Application for a Non-Material Amendment Following a Grant of Planning Permission

Erection of ground floor side and rear wraparound extension, first floor side extension and all associated works.

BH2023/03316

Alteration to rear glazing replacing bi-fold doors for a window

Rear Elevation

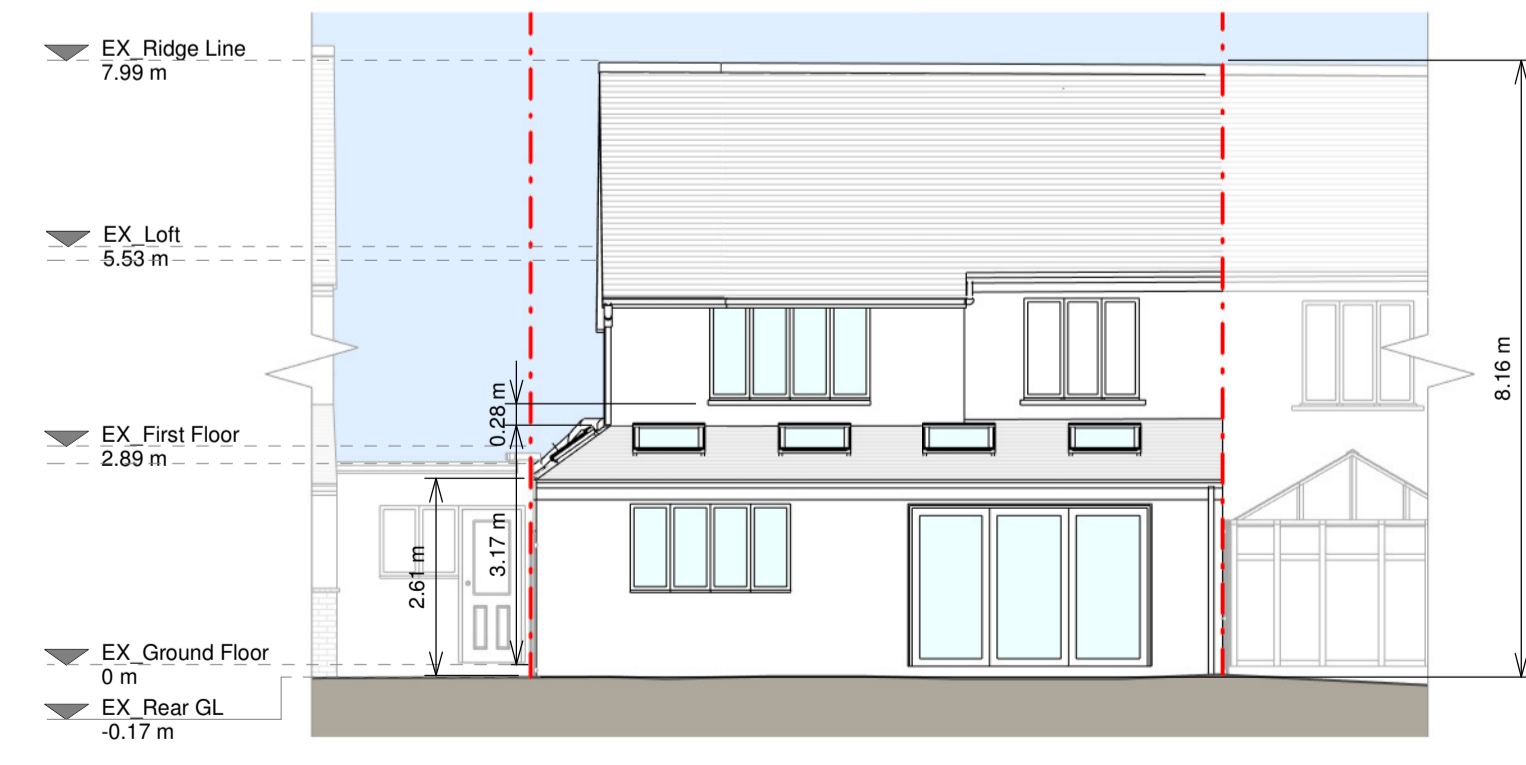
Required for internal kitchen alterations
